Our Case Number: ACP-323410-25

Re: Proposed Limerick City Greenway (UL to NTP)
Within the townlands of Dromroe, Sreelane, Newcastle and Castletroy, Co. Limerick.

Addressee: An Coimisiún Pleanála Case Number 323410

Title: **Limerick City Greenway (UL to NTP)**

PHOTOMONTAGE VIEW

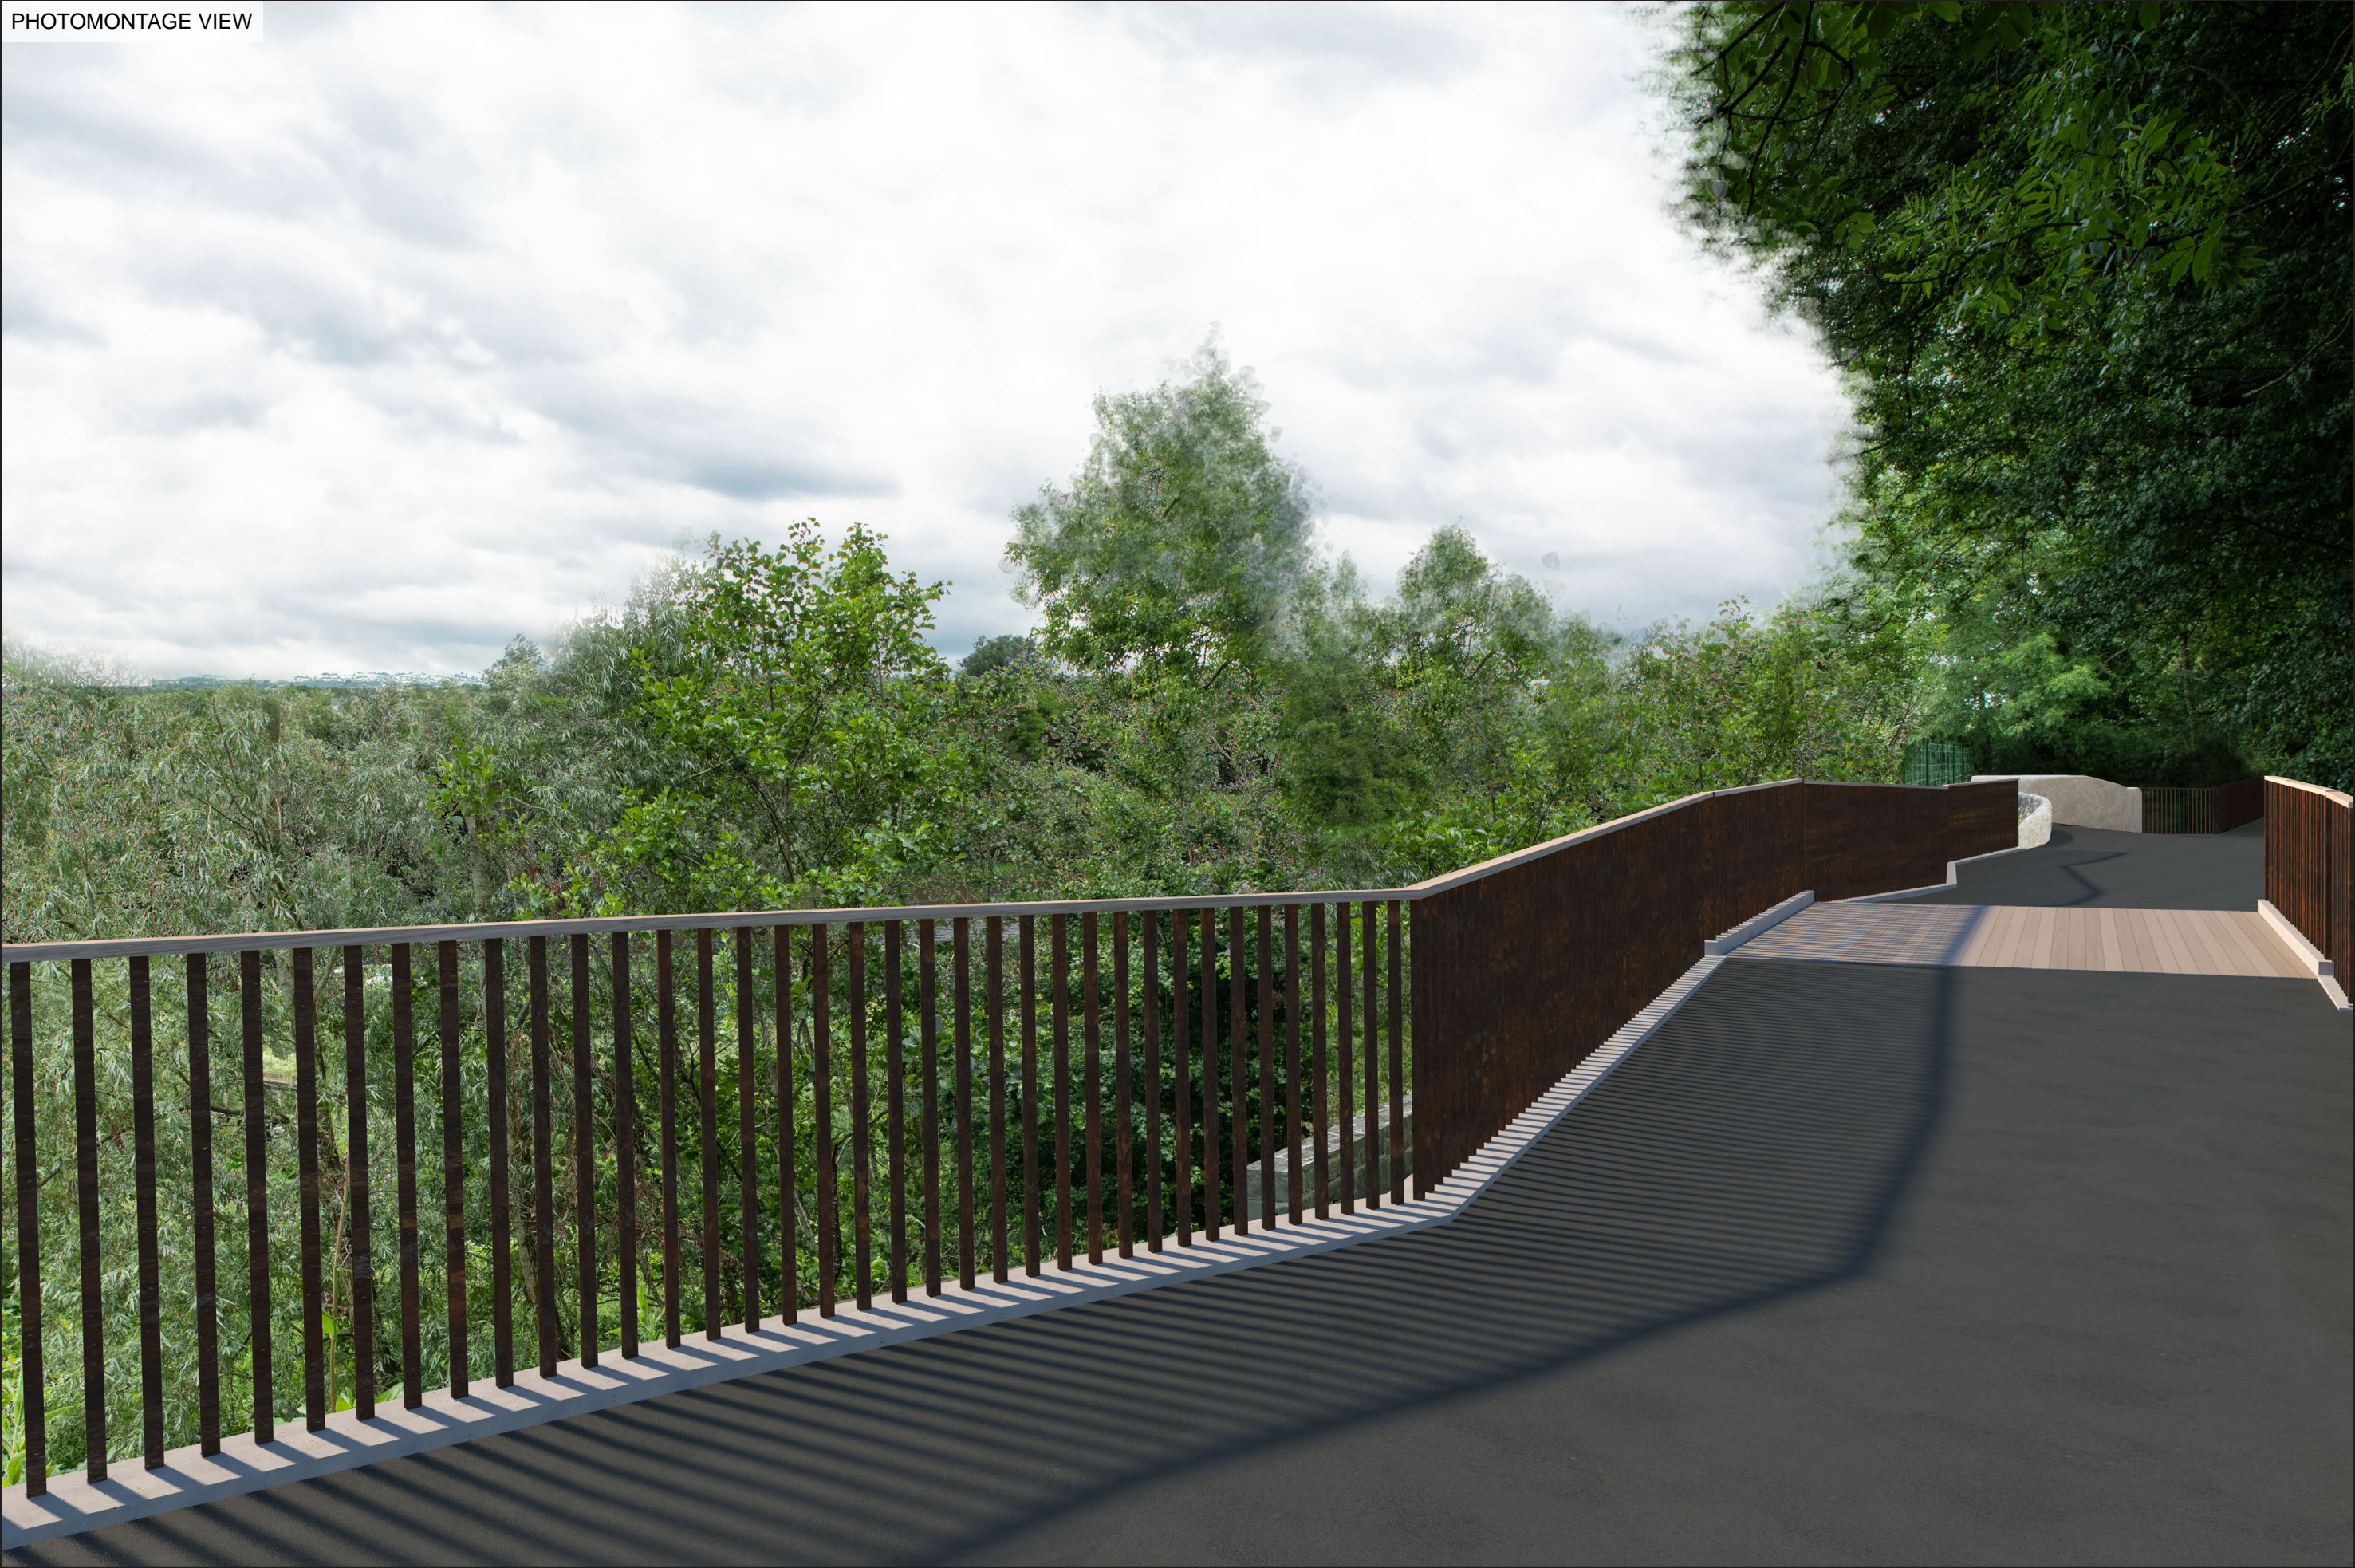
Proposed layout at Groody River Bridge area - see comments below in Section 2.5

However, we are confused by the proposal at the very beginning of this project at the River Groody, as outlined in the photomontage above, which appears to show a complete blockage of the existing riverside path to other than pedestrians, and even at that, for pedestrians it would appear entrance would be with some difficulty? This design needs to be clarified.
